OXFORDSHIRE COUNTY COUNCIL'S RESPONSE TO CONSULTATION ON THE FOLLOWING DEVELOPMENT PROPOSAL

Application no: 23/02399/REM

Proposal: Reserved Matters approval for 23/01080/OUT - Details of access, appearance, landscaping, layout and scale relating to the proposed development of Class E(g)(i) (formerly B1(a)) office/commercial building and Class E(g)(ii) (formerly B1(b)) Research and Development Units, plus associated car parking

Location: Land North Of Bicester Avenue Garden Centre, Oxford Road, Bicester

PROJECT		BICESTER ARC	
TITLE			
ZONE B		SITE LAYOUT PLAN

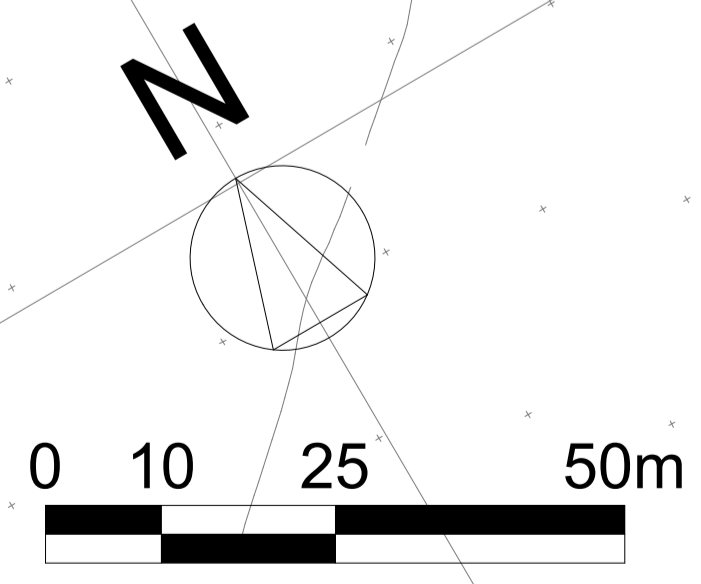
I acknowledge the need to separate delivery HGV's from the rest of the site. However, the submission has not included swept path drawings that demonstrate the ability of HGV's accessing the yard and turning around to egress in forward gear.

Up to 238 car parking spaces are earmarked to serve both buildings. This provision is 13 spaces over and above the standards. see link below.

It is also noted that only 24 car parking spaces are proposed to have EV charging ports out of 238 parking spaces. This is significantly below the level stipulated in the County's Electric Vehicle Infrastructure Strategy which categorically requires at least 25% of the

spaces to have charging points installed for non-residential developments. This is under Policy EVI 8 and must be adhered.

The Site Plan shows two areas of cycle parking to the north of the Building A. From this illustration, I do not consider their ability to accommodate sufficient spaces for cycle storage to the level required for such a type and scale of development. See Table 5: Non-Residential Parking Guidance for Oxfordshire in OCC's Parking Standards.

In addition to the level of cycle parking on site, we require at this stage to see the detail of the cycle design. Acknowledging that Sheffield stands are most preferable for users, these command a large footprint particularly where a big allocation is required and double stacked types can be a sensible option.
